Your Ref:
Our Ref: FN/4/12/
Please ask for:
Mr J Smith

29th February 2012

Proposed rear extension & dormer to side (this application lies within the South Downs National Park Authority)
Glenthorne Findon Road Findon

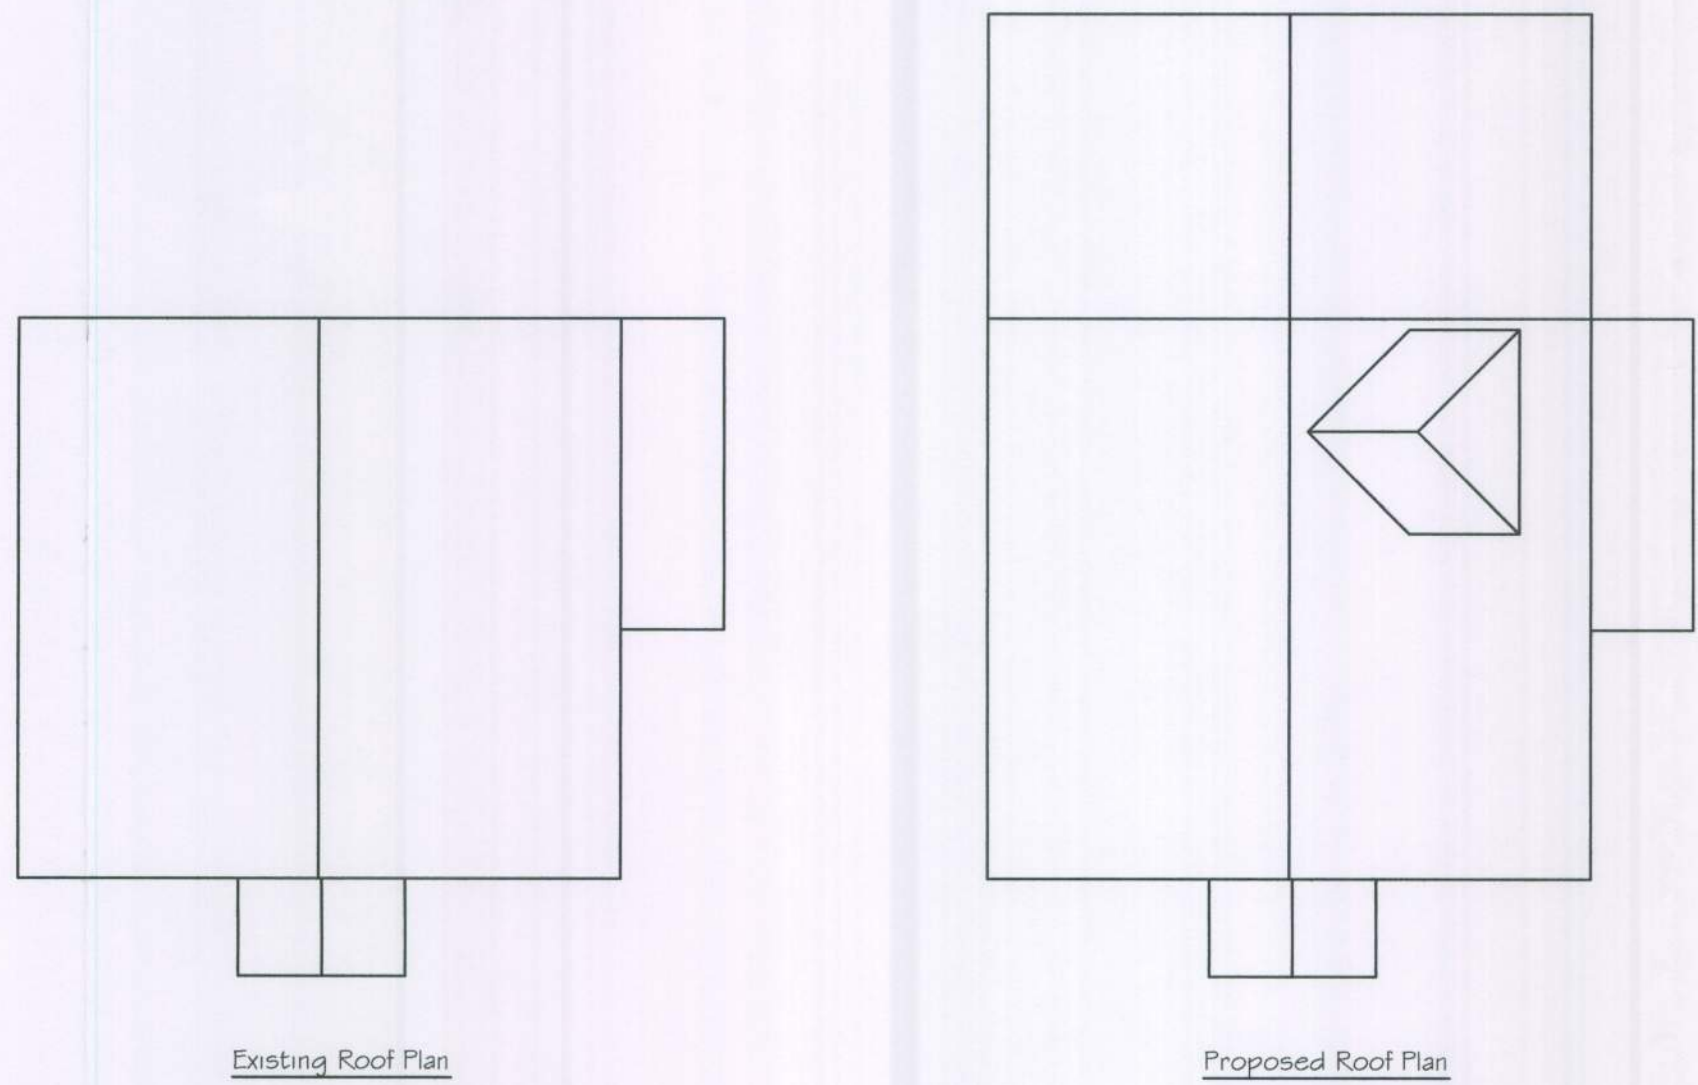
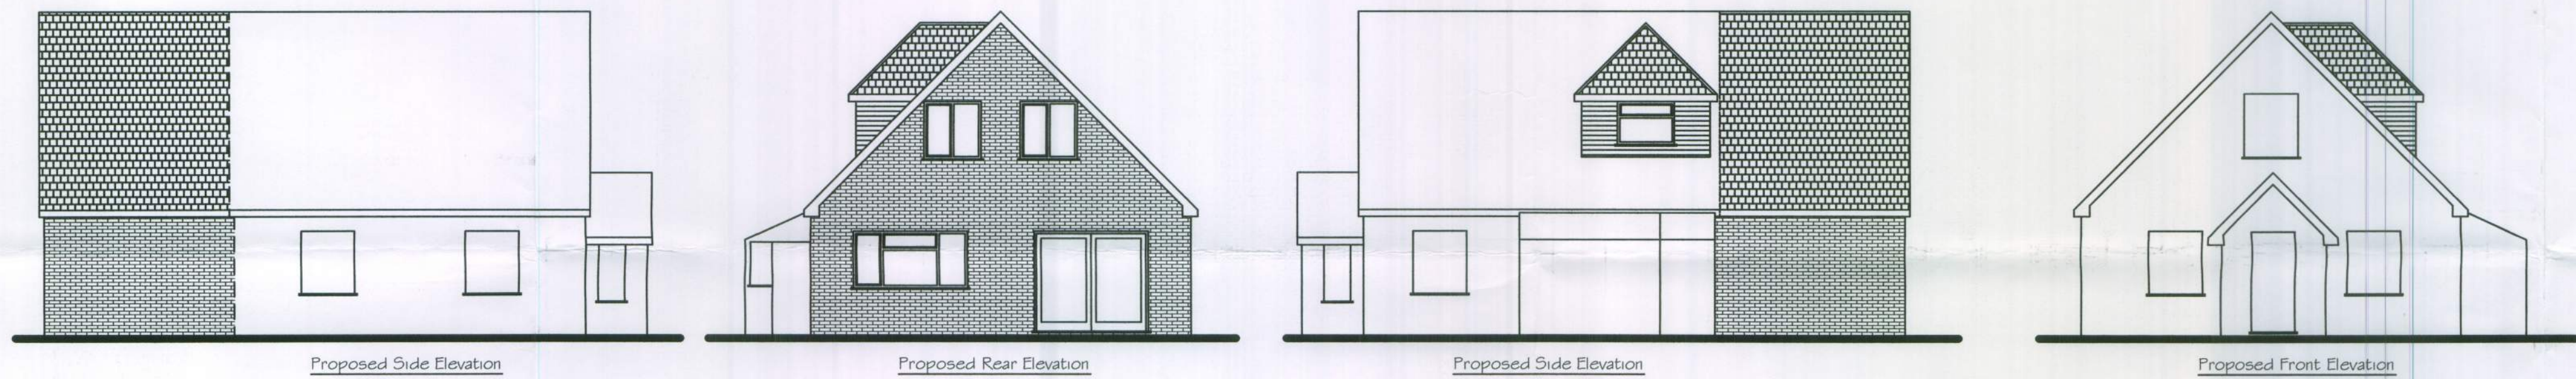
Findon Parish Council Planning Committee have considered the application submitted under ref: FN/4/12 and although having no objections to the proposed extension and installation of a side Dormer, they respectfully suggest that if the ADC Planning Officer is minded to approve the application, it be a condition of approval that the Dormer be installed with obscured glazing.
